Re: CCCC Signage Master Plan

This letter is intended to serve as a letter of approval concerning a revised signage master plan submitted via email on March 3, 2014 for the Cumberland County Civic Center pursuant to condition 6 of the Planning Board approval letter of August 14, 2012. Approval of the signage master plan is subject to a number of conditions which are listed below.

Future location for building naming rights partner signage to be located above Marquee.

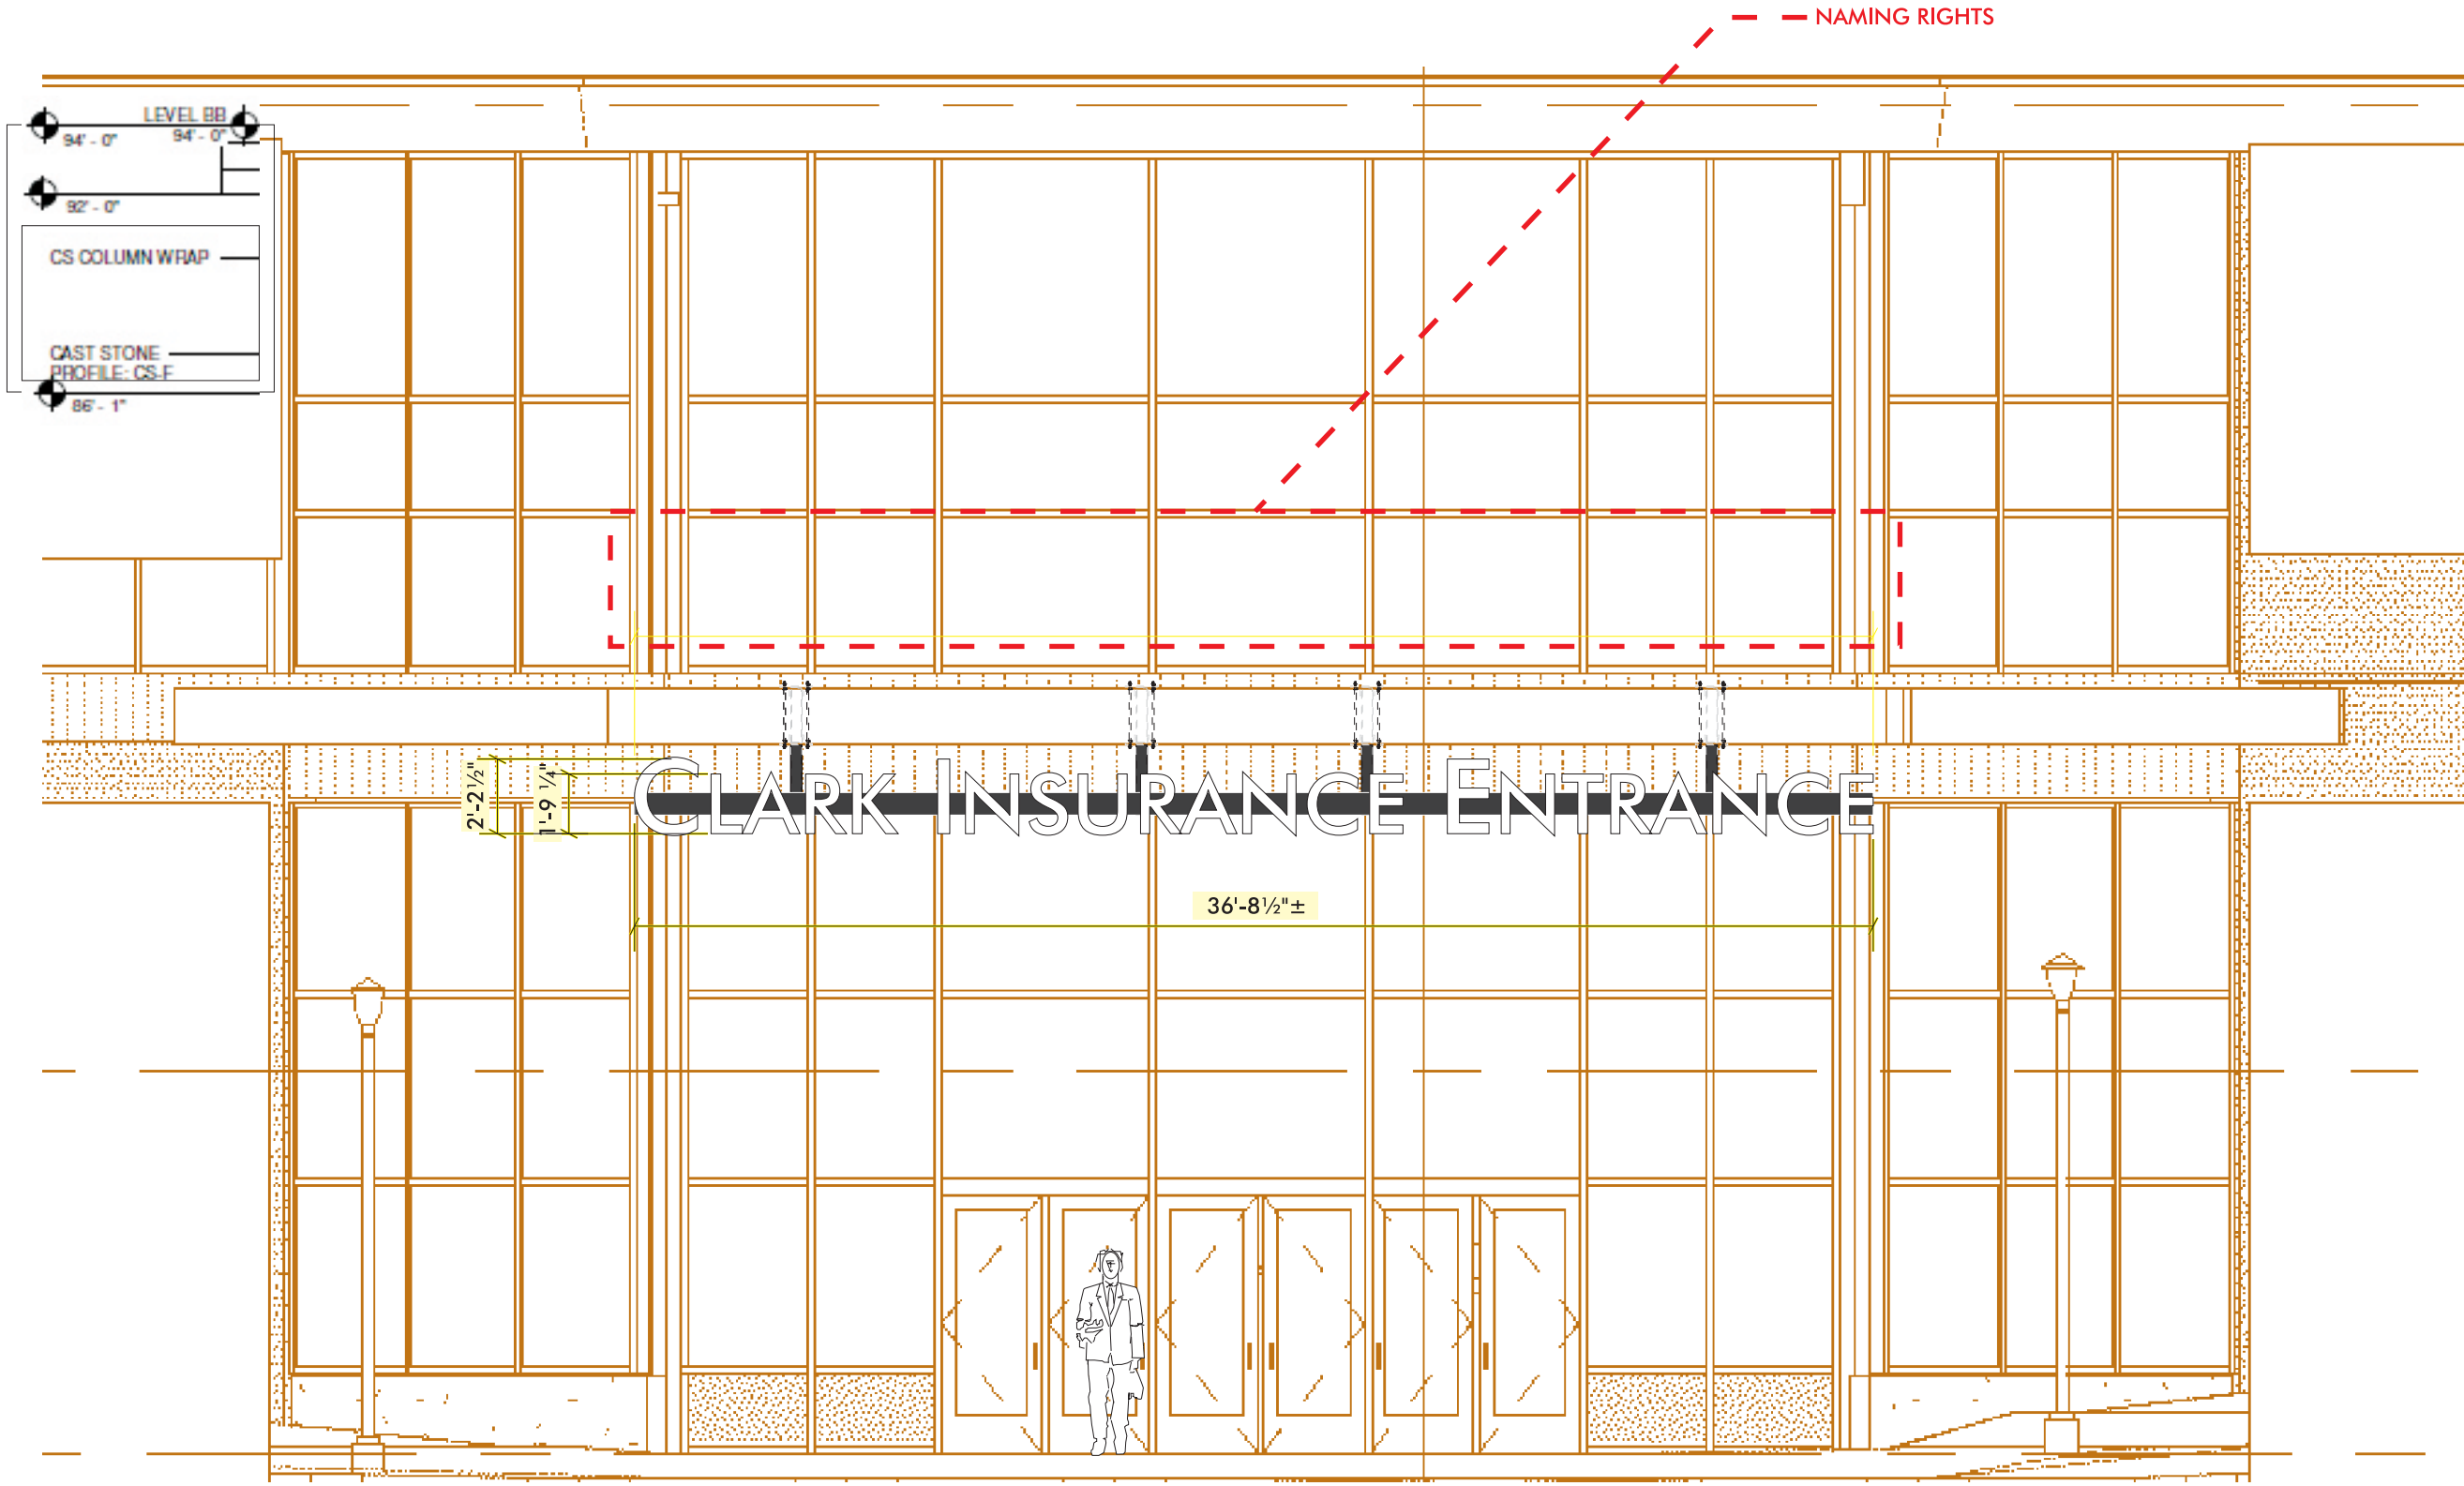
On the upper portion of the CCCC façade the plan references "Future location for building naming rights partner signage". Approval is for the general location of the sign and not the size or the design of the sign. When a specific sign proposal comes forward, the size and design of the sign shall be reviewed by the Planning Authority accordingly. The large existing Cumberland County Civic Center sign along Spring Street shall therefore be removed when a new building naming rights partner sign has been approved by the Planning Authority.

Clark Insurance Entrance sign is acceptable provided that the sign is recessed a minimum 18 inches from the marquee support. Upon submission of a marquee or naming rights partner sign, the treatment of the support system shall be integrated into the overall design of the future marquee and building naming rights sponsor sign. Specific details of the marquee and building naming rights sponsor sign shall be subject to Planning Authority review and approval.

Note this approval anticipates only one marquee for the CCCC which would be located at the Southeast Entrance.

Future location for building naming rights partner signage. See detail on following pages.

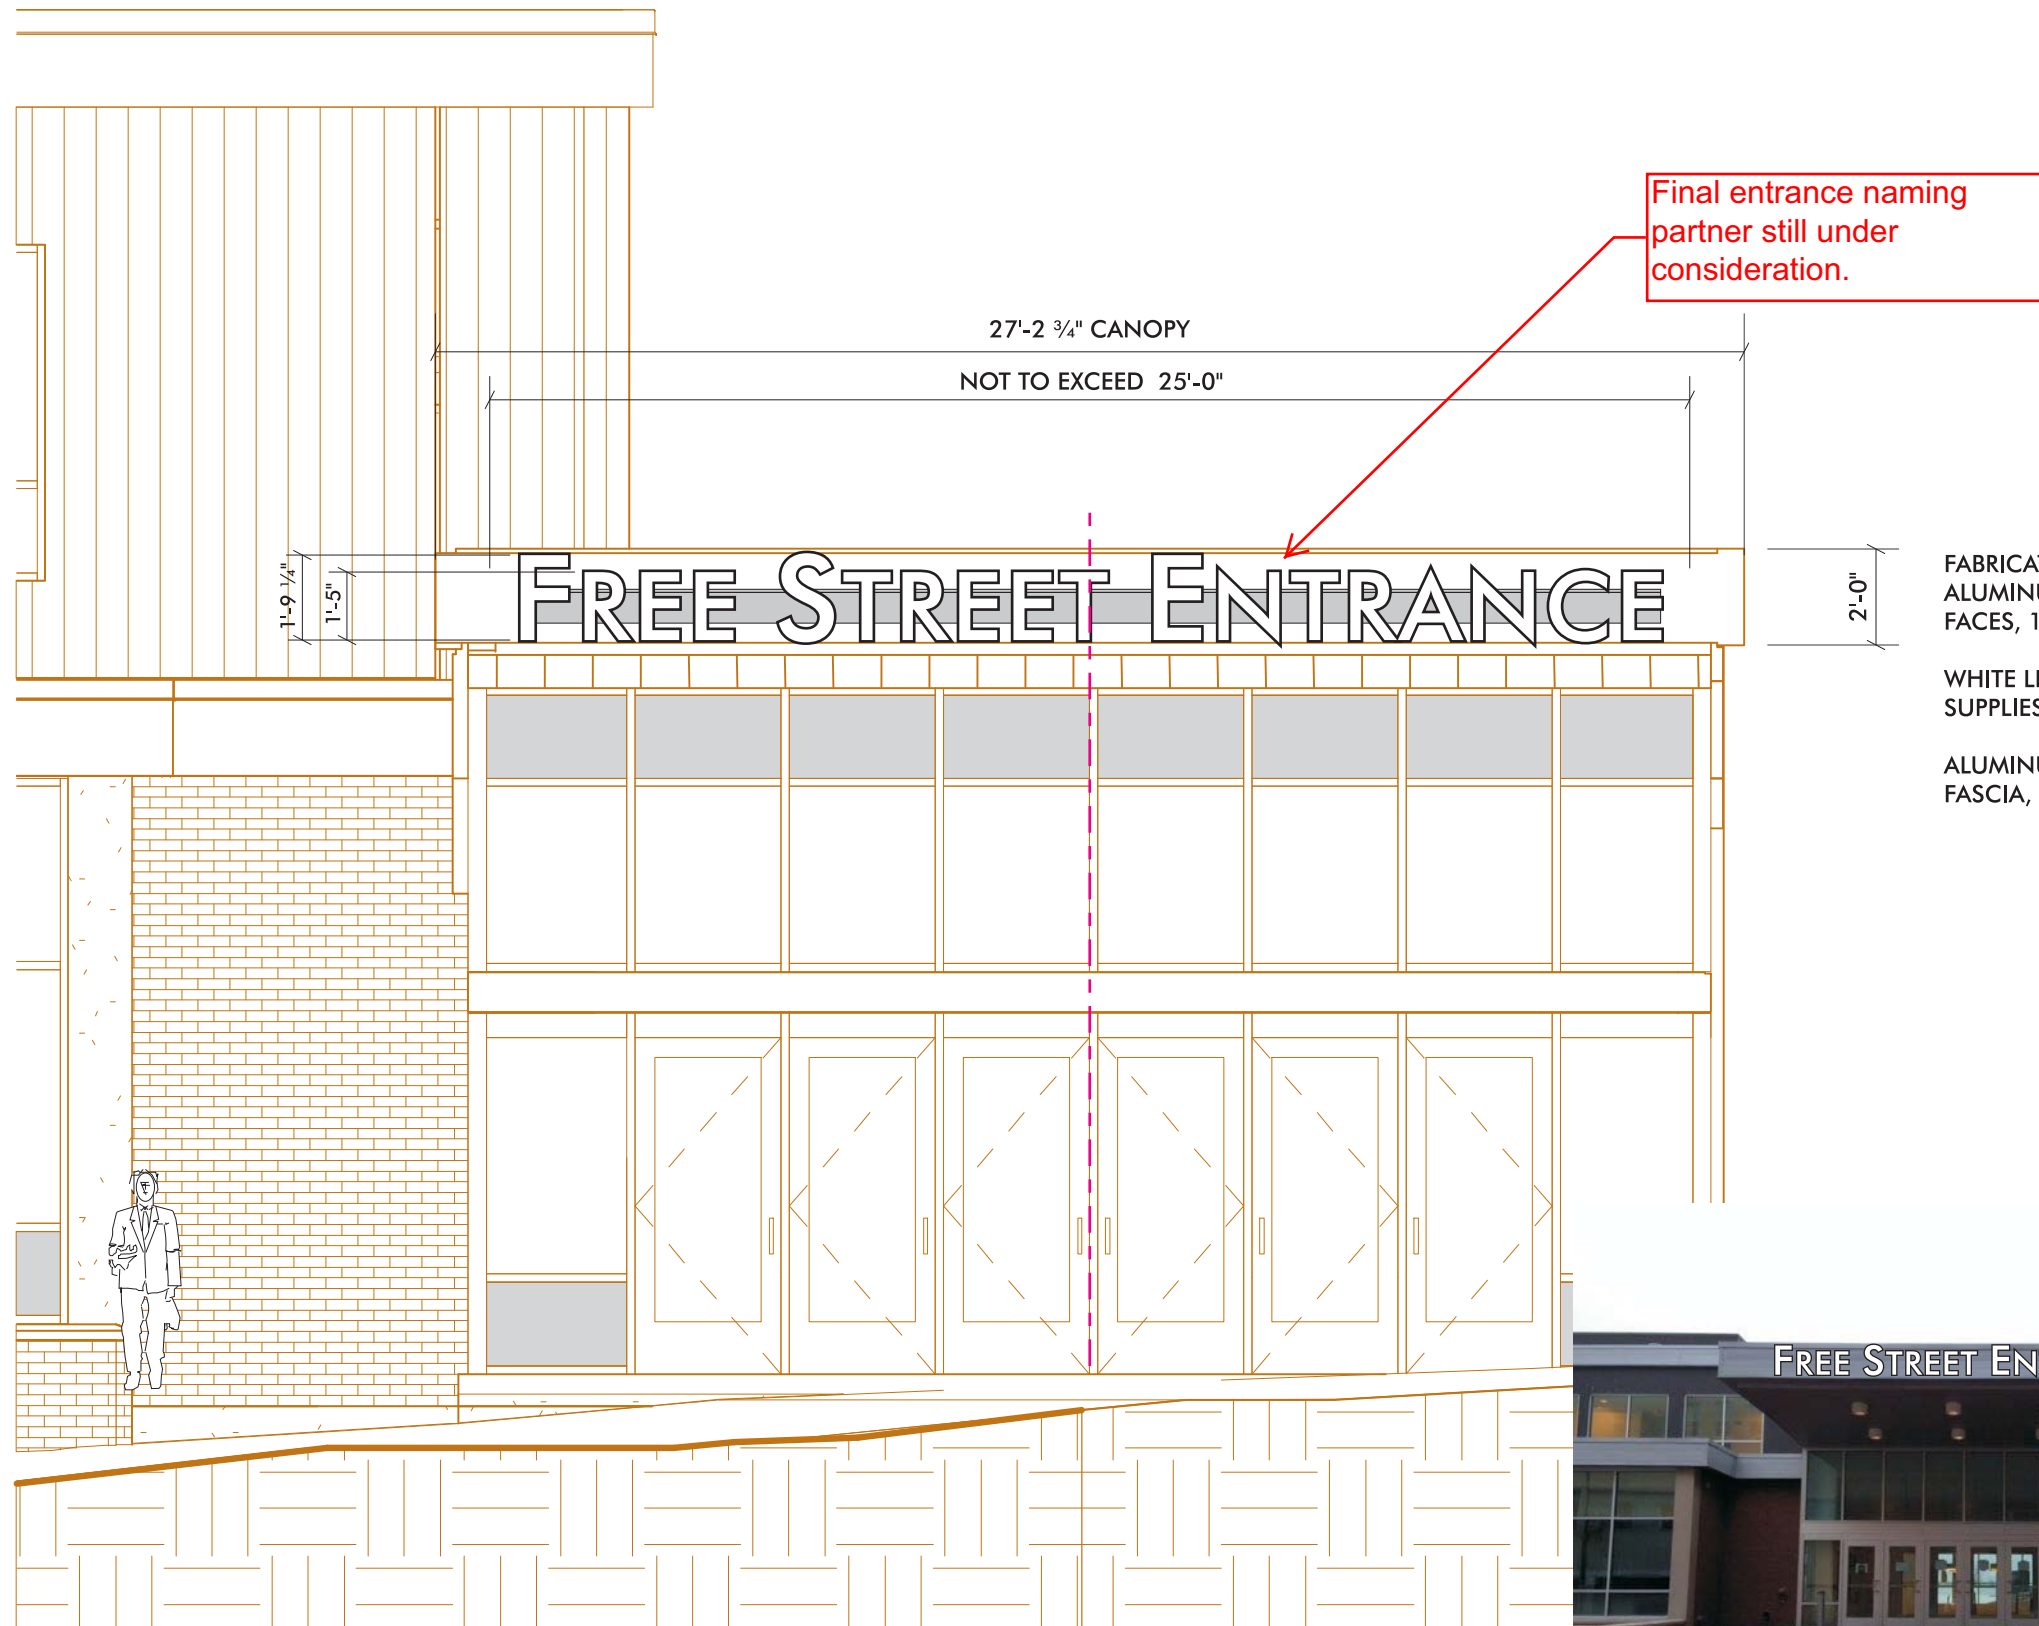
The future building naming rights partner signage is acceptable but only as to general location. The size and specific design detail of the signage shall be subject to Planning Authority review and approval.

ENTRY ID 2 OF 3—SPRING STREET ELEVATION—INT. ILLUM. ENTRY ID LETTERS ON FASCIA

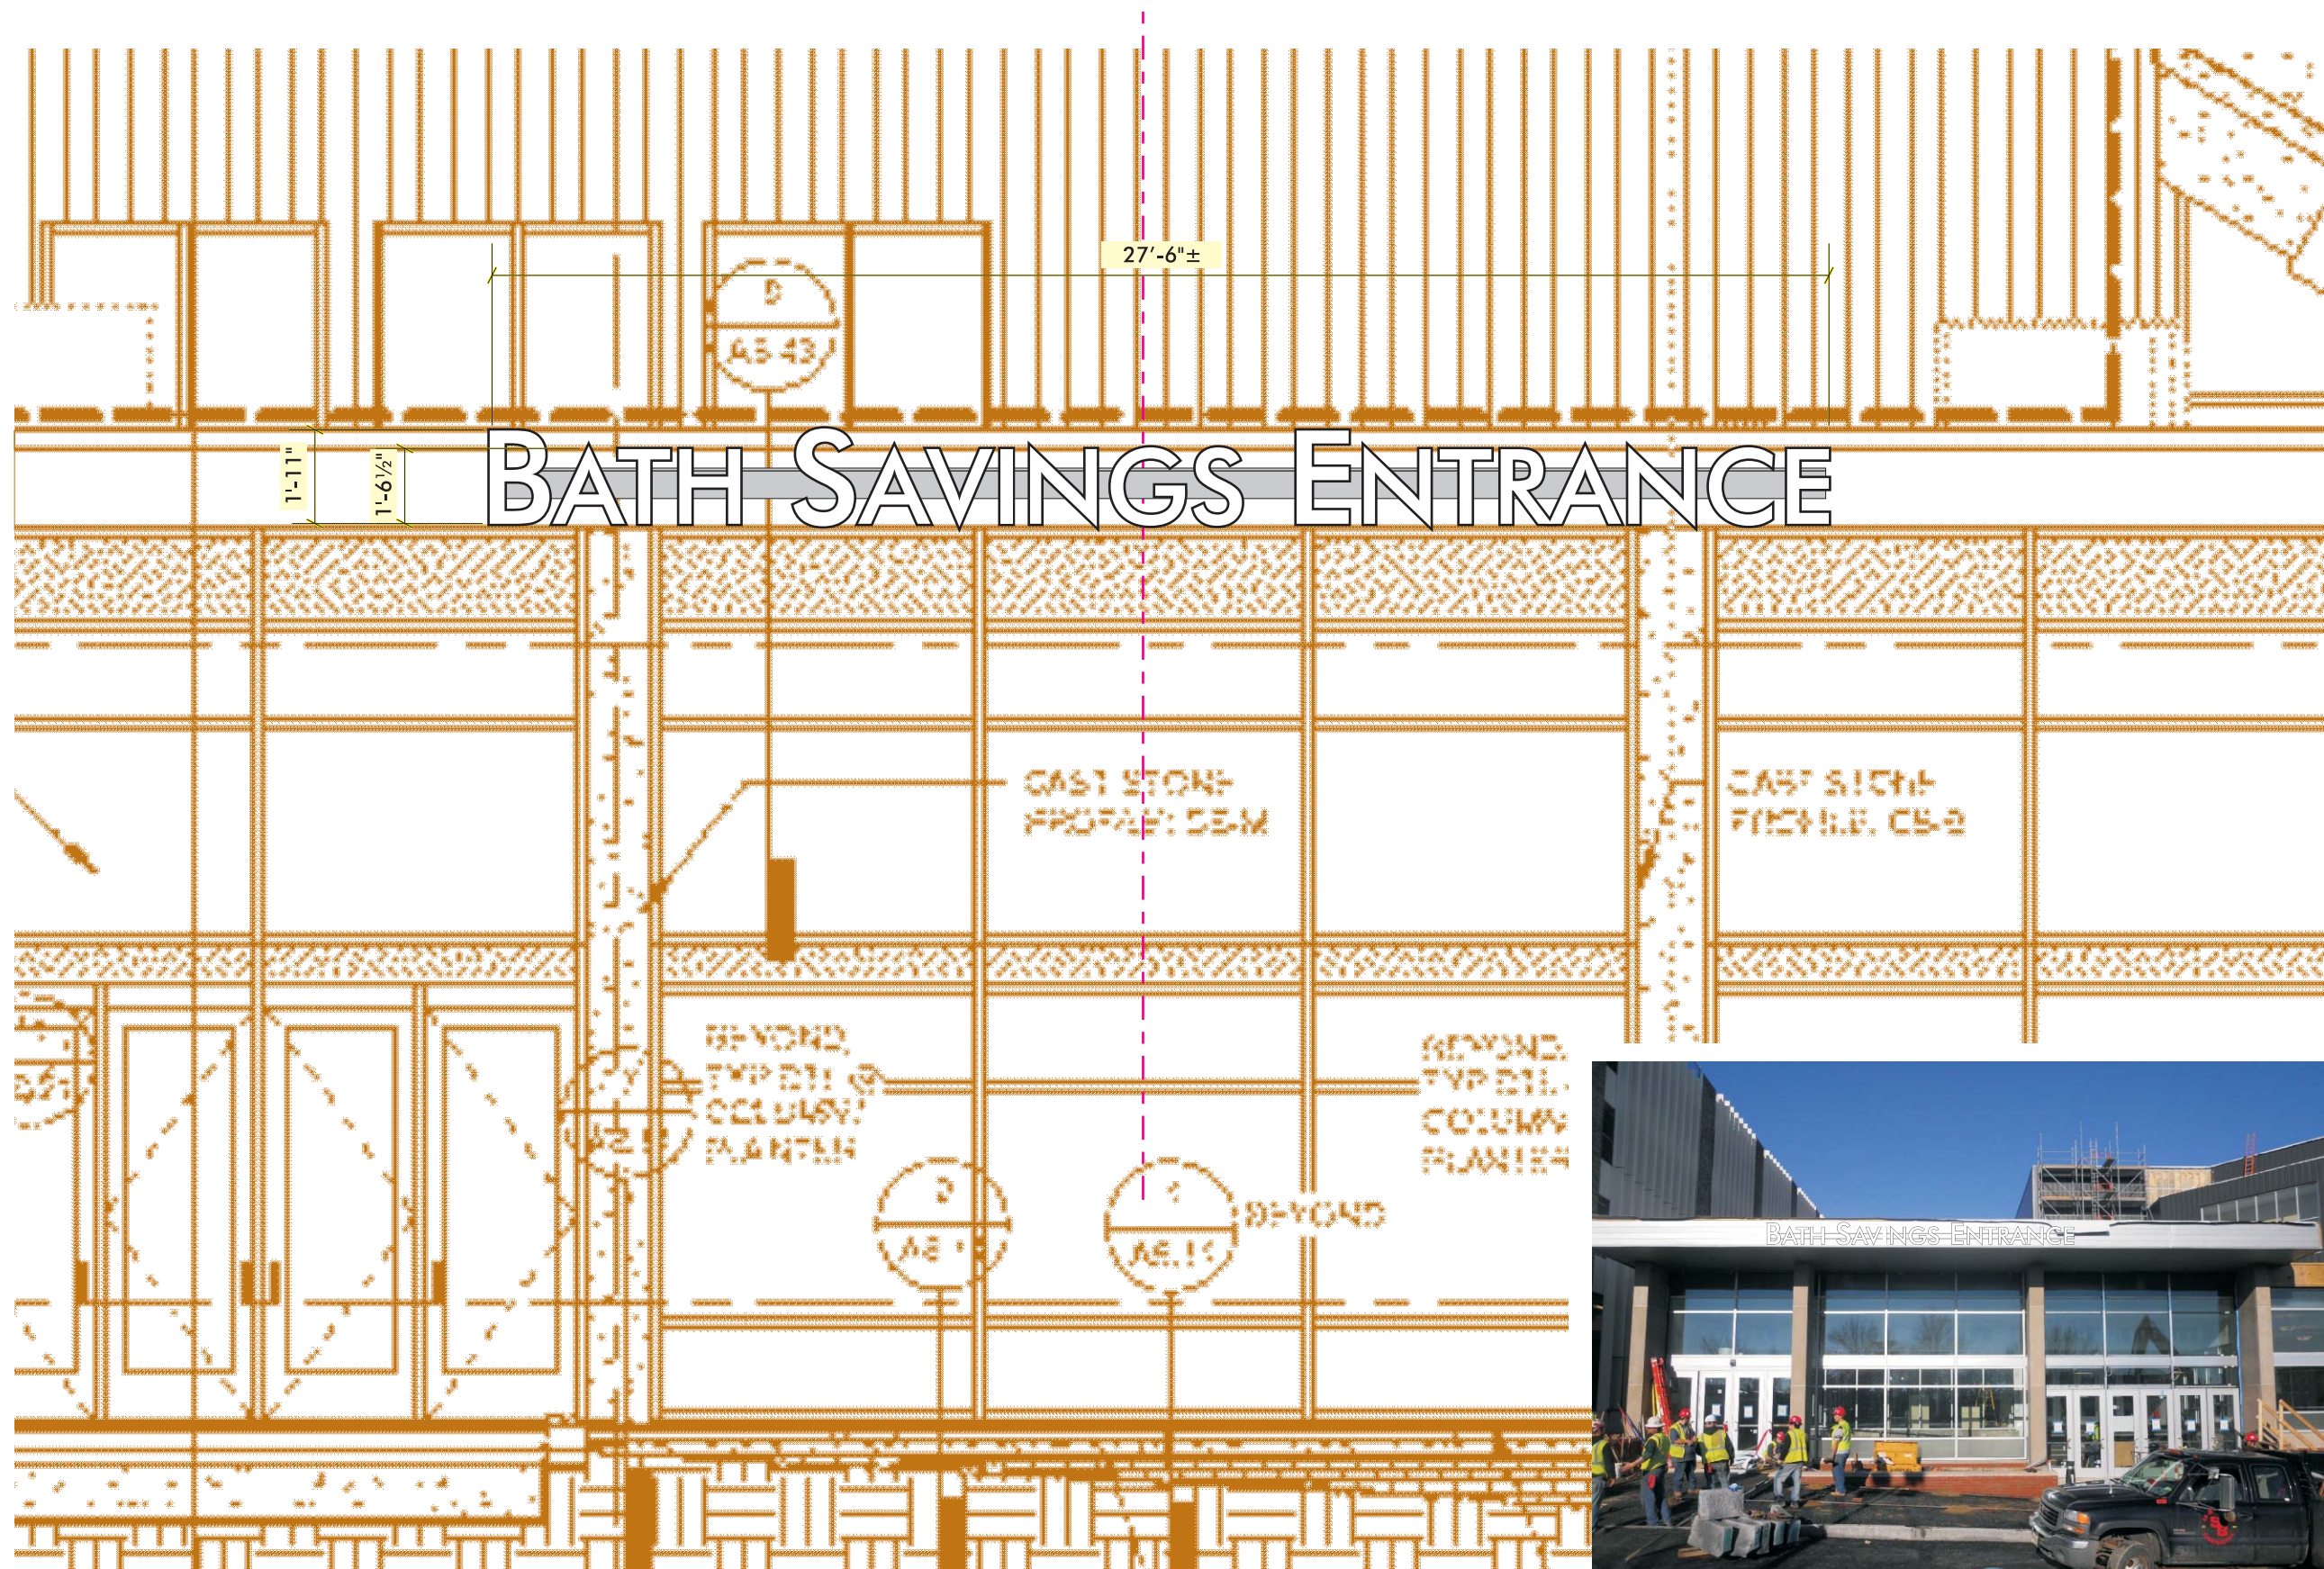
Bath Savings Entrance Sign (Spring Street)...Sign is acceptable provided that letters are reduced in size providing a min. 1 inch border at the top and a min. 1 inch border at the bottom of the letters.
